Application Ref: H09-0721-25

Proposal: **Development of 57 affordable dwellings with associated access, open space and drainage**

Location: **Land south of Wignals Gate, Holbeach, Spalding**

Revised interim response with additional comments following an internal Design Panel Meeting.

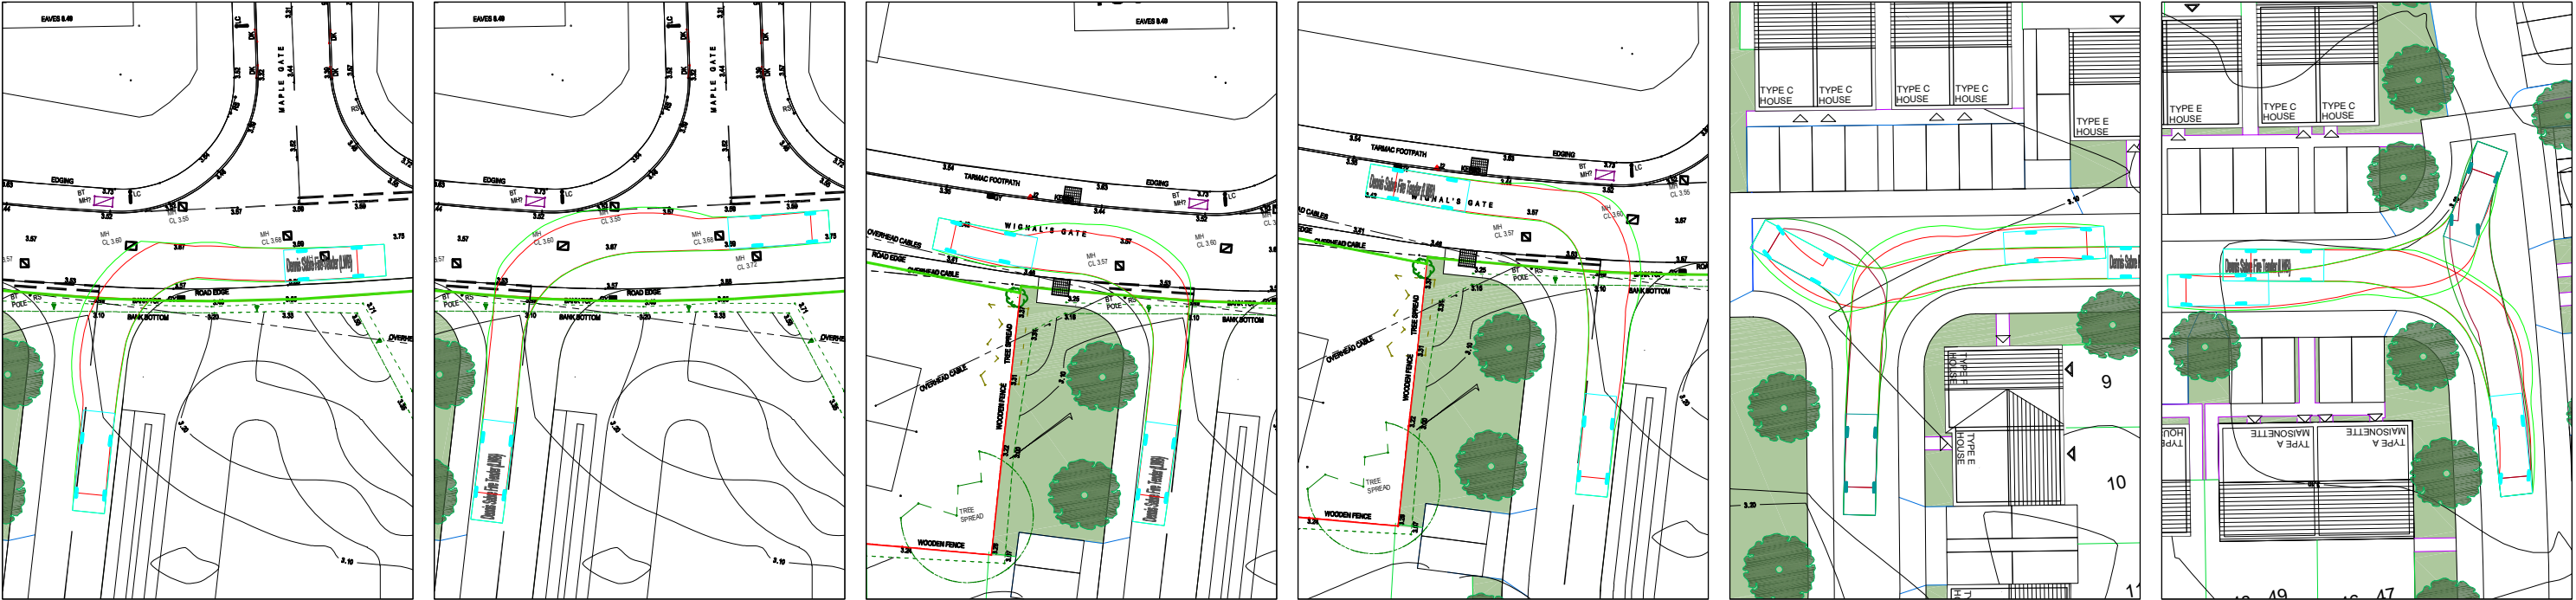
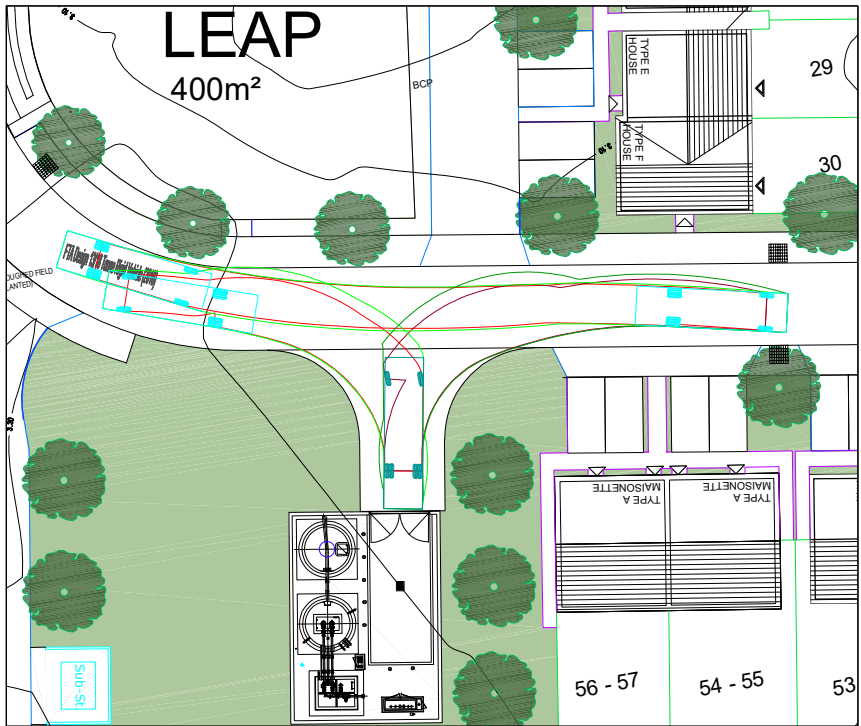
An edge lane should be incorporated into the layout instead of the two private drives to provide connectivity and the vehicle tracking does not work for a refuse vehicle as they should not overrun the footways. This looks to happen on several bends/turning areas.
